Date: 10th June 2019

Planning Application 3/2019/0439: Prior notification of the construction of a new forestry access track, Land off Easington Road, Cow Ark BB7 3DH

Planning Officer (Archaeology)

Proposed Access Track
(Scale 1:500)

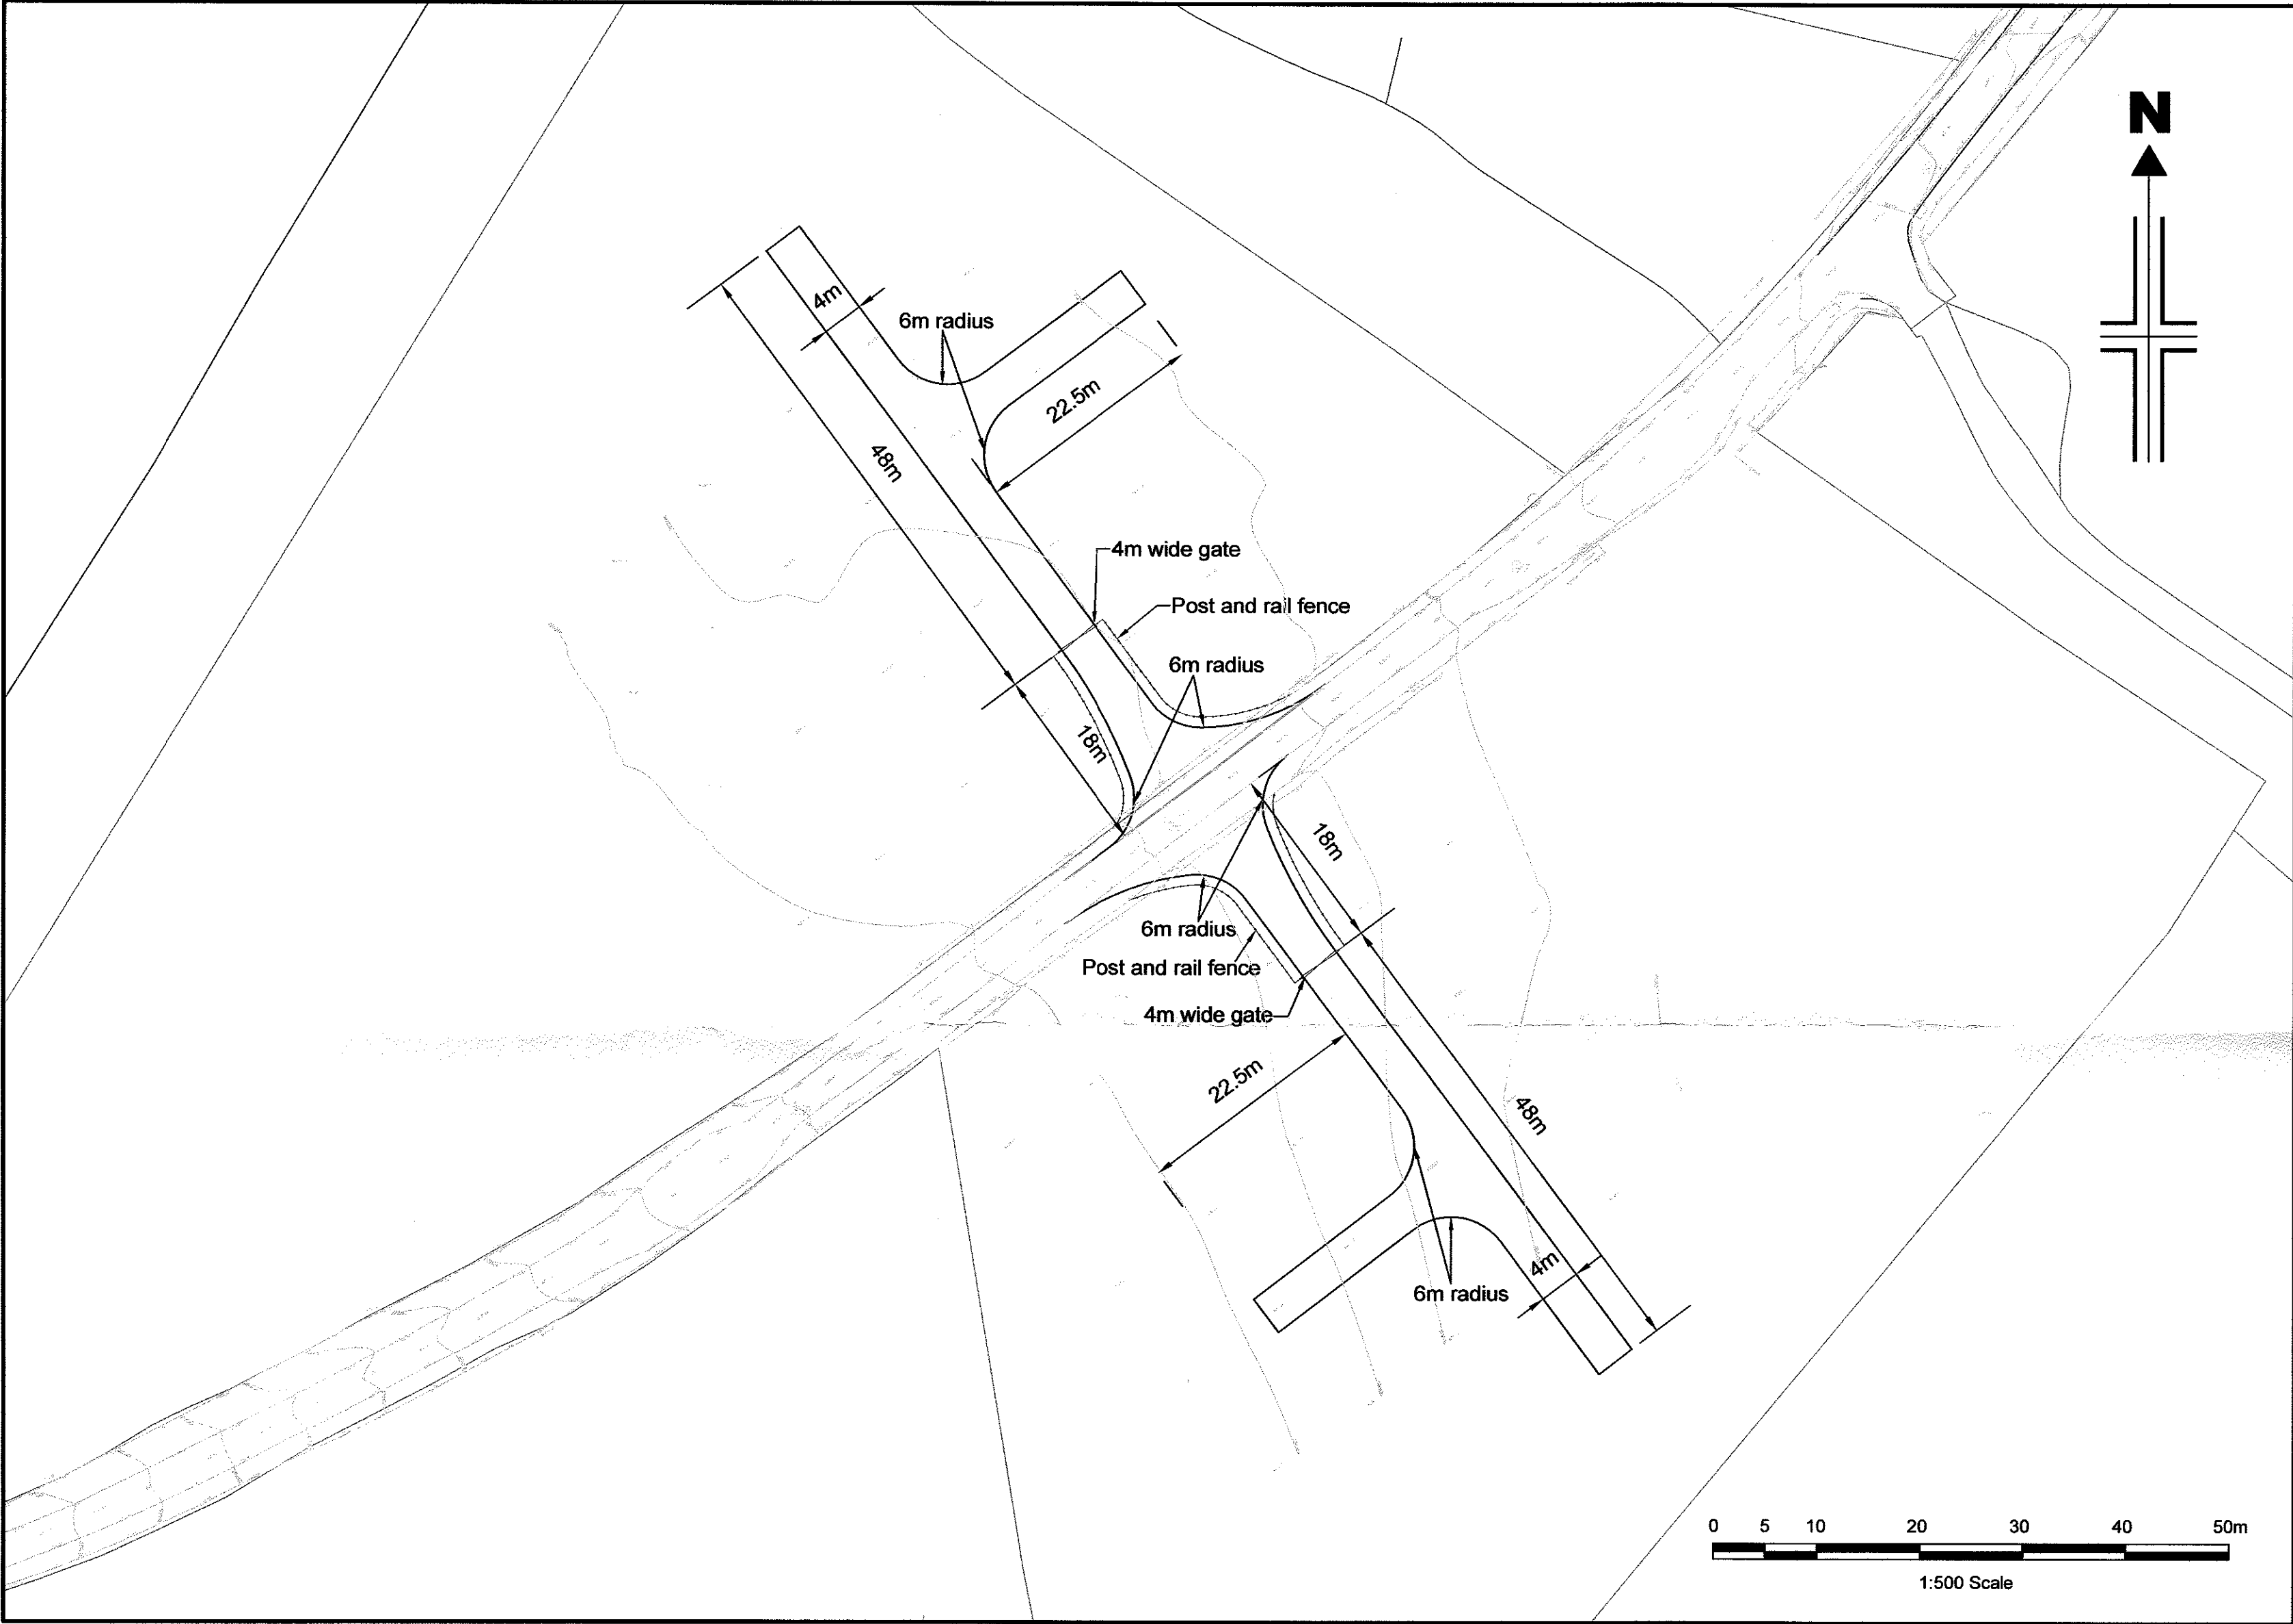
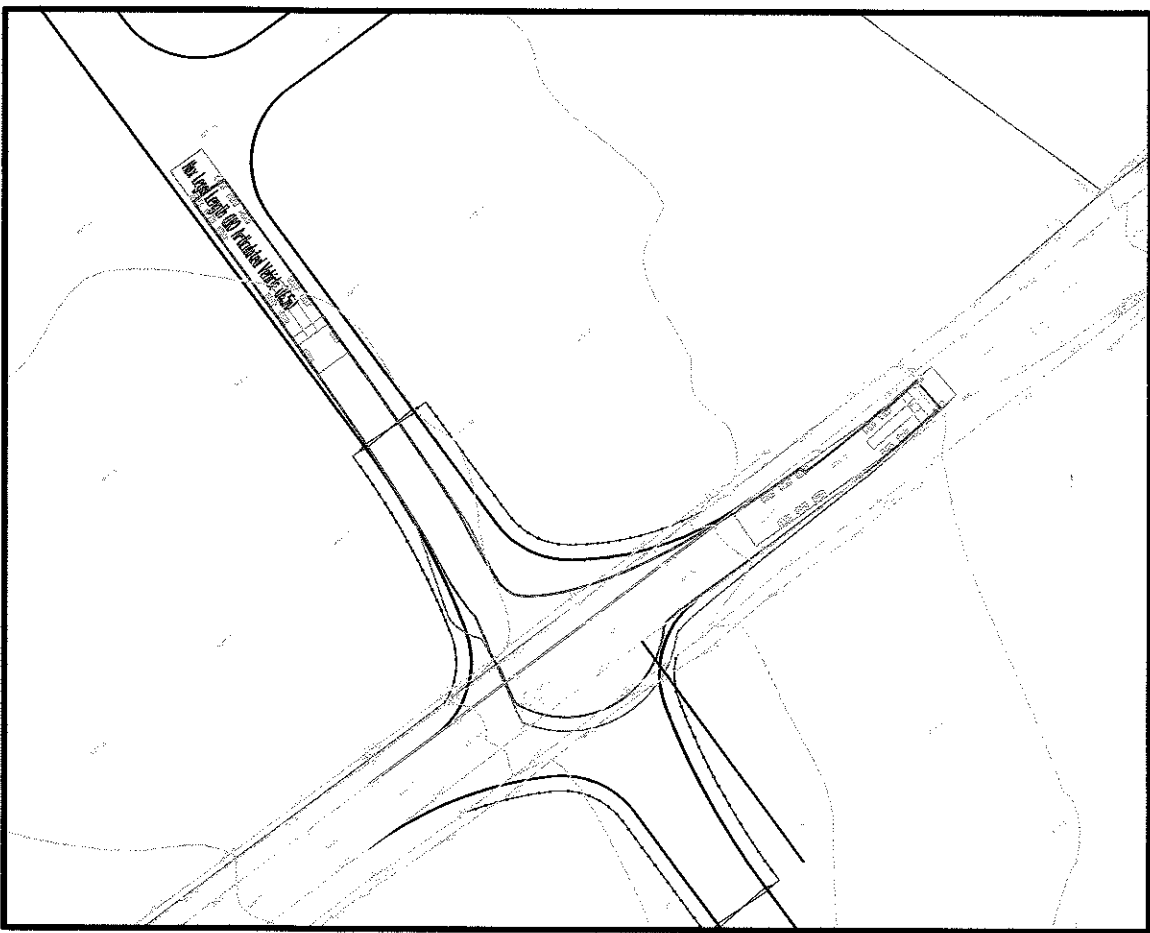
The segment which runs north west from Easington Road towards the forestry plantation boundary is potentially more problematic. There are no known sites or monuments recorded in the field crossed by the road but immediately inside the boundary of the plantation is a length of the Roman Road which ran between forts at Ribchester and Tebay which is protected as a Scheduled Monument..

The construction of this access track will not affect the monument but any extension to access the plantations will cross the end of the monument and this will require Scheduled Monument Consent from the Secretary of State for Digital, Culture, Media and Sport who are advised on such application by Historic England.

Alternatively, the north eastern edge of the Scheduled area ends about 20 metres south west of the northern corner of the field in which the track is proposed. The monument edge runs SE – NW approximately parallel to the north eastern field boundary and so the road could be aimed to create a route through this gap. Such a route would still cross the Roman Road line when extraction work begins however and measures should be taken to avoid damage at that time.

I would advise the applicant to consult Historic England to discuss the proposed access track route and any further work proposed in the forestry plantations enabled by this

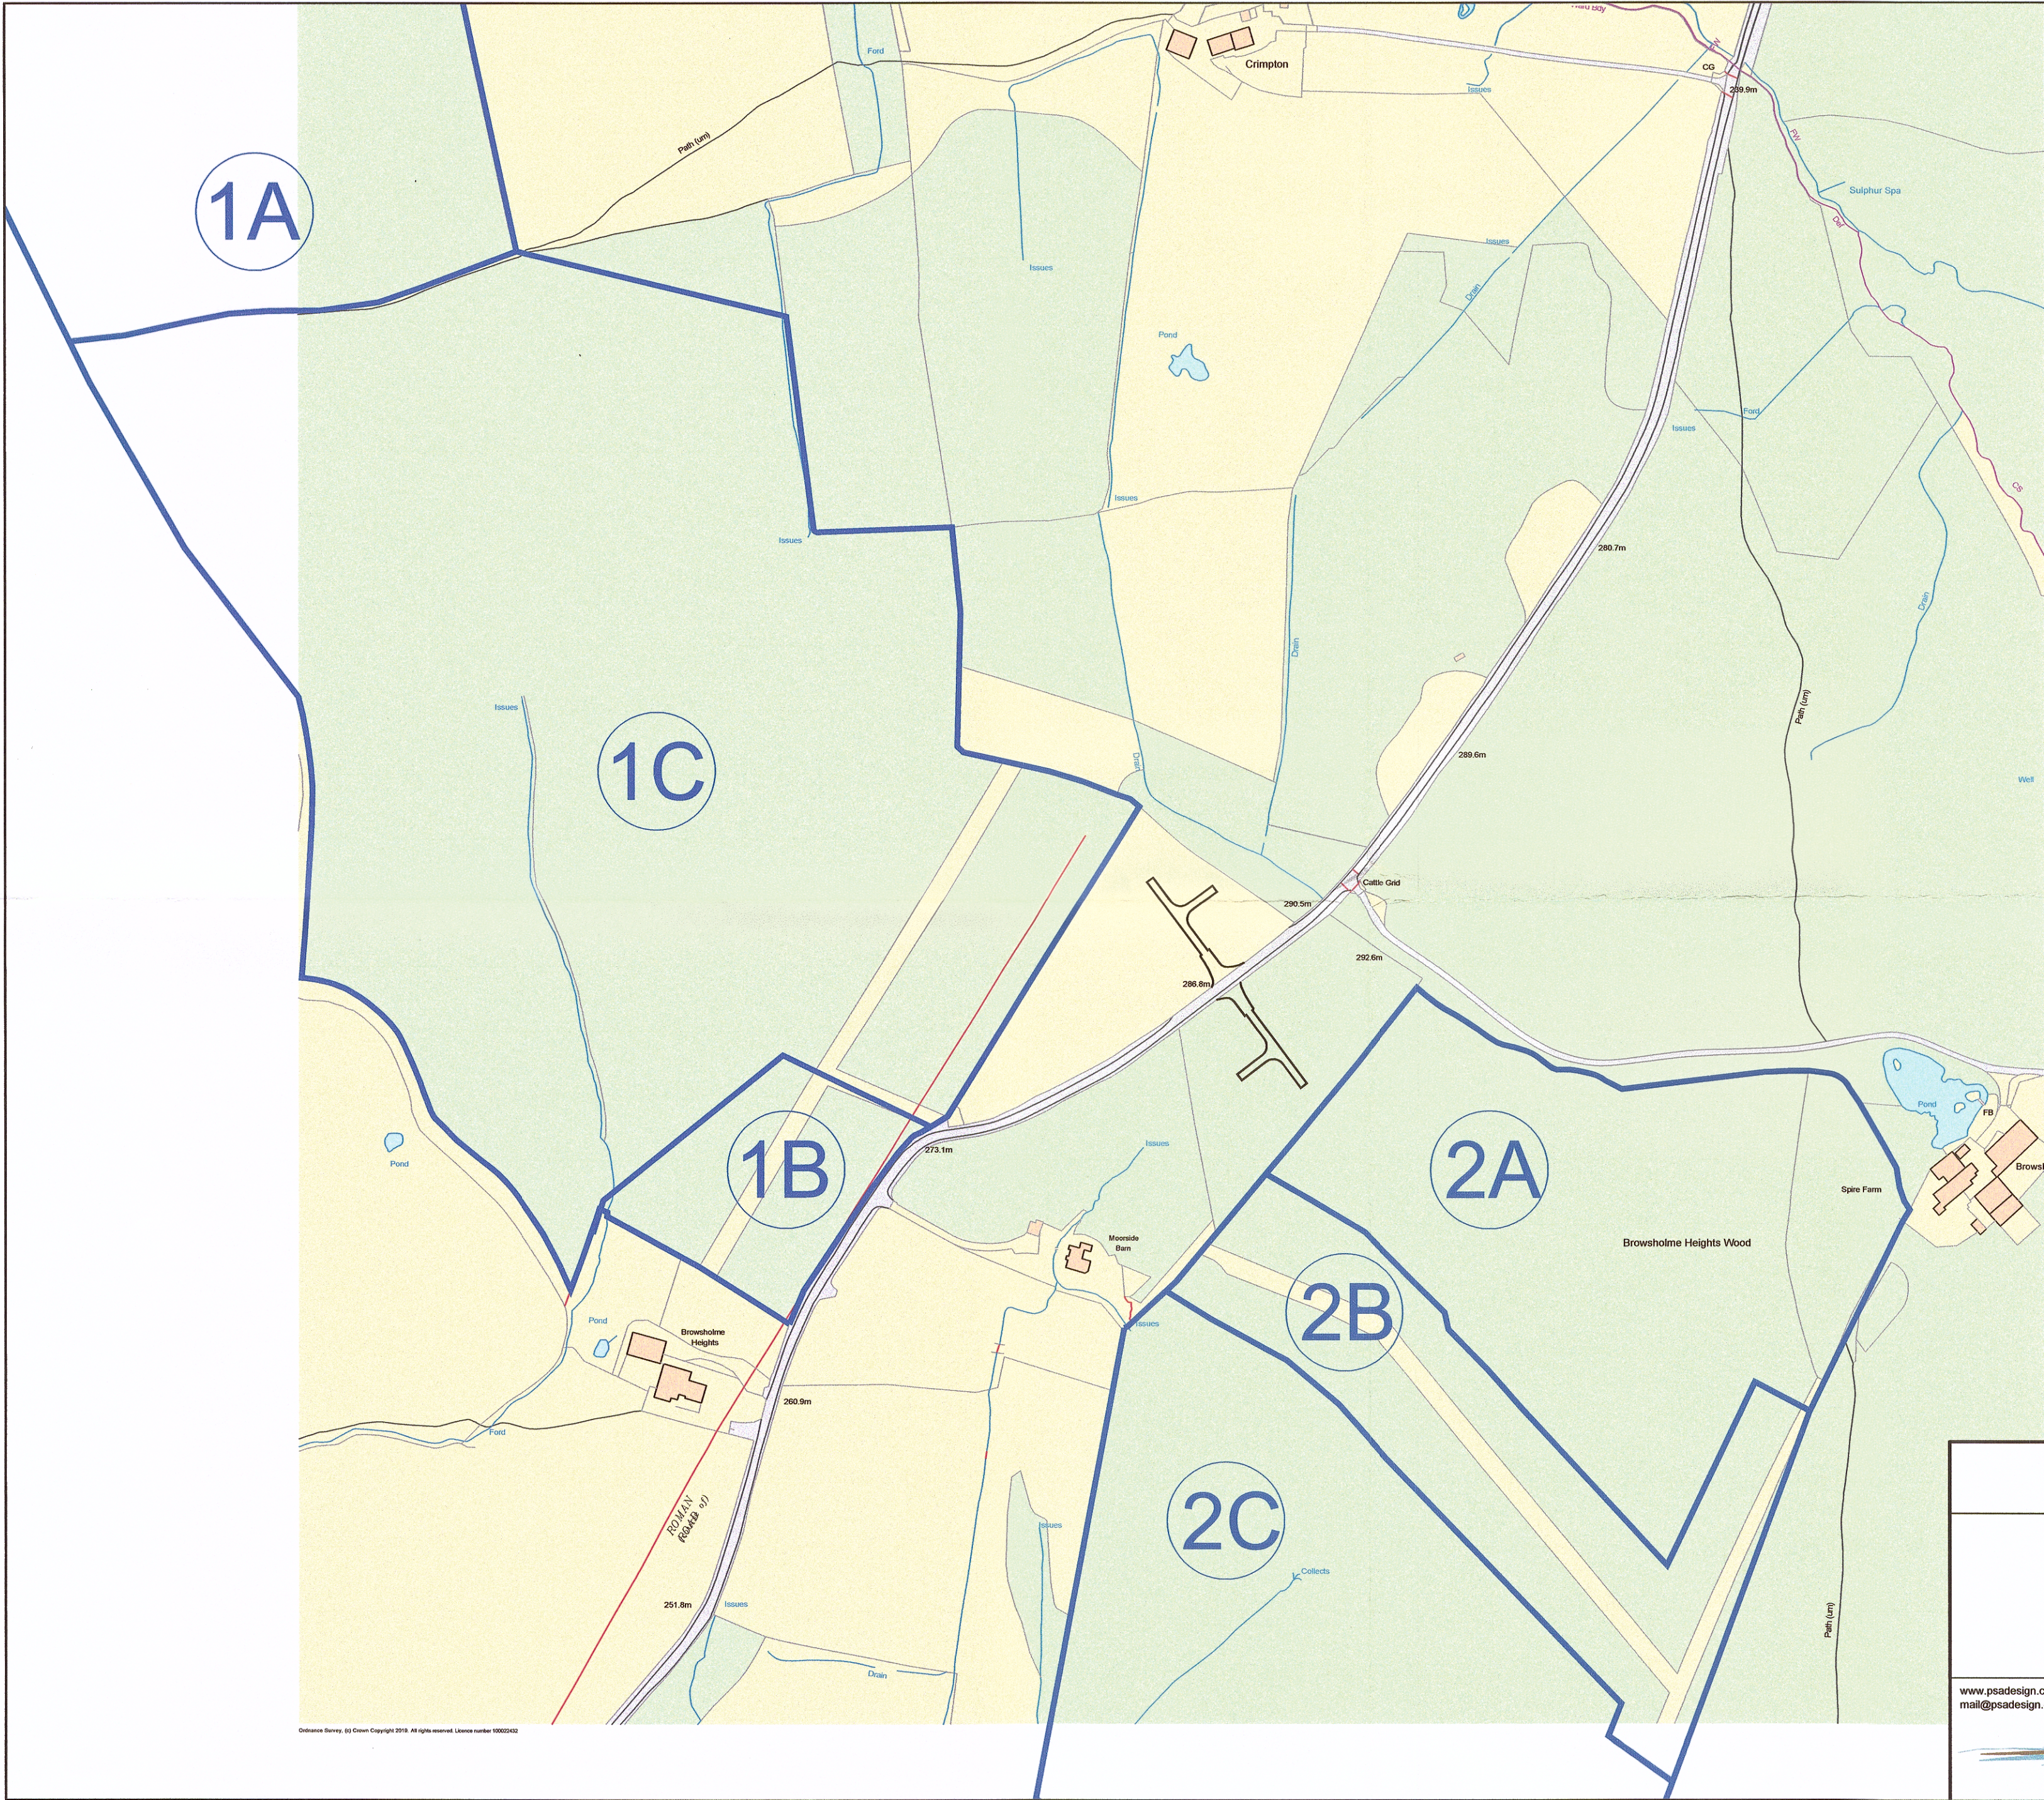
The above application can be considered in two separate parts. The construction of the new access track running south east from the Easington Road does not appear to create any difficulties, there being no recorded sites or monuments along the line, or indeed in the woodland which is will access (although woodland is notorious for concealing archaeological sites and monuments and there may be unknown and unrecorded sites within this area).
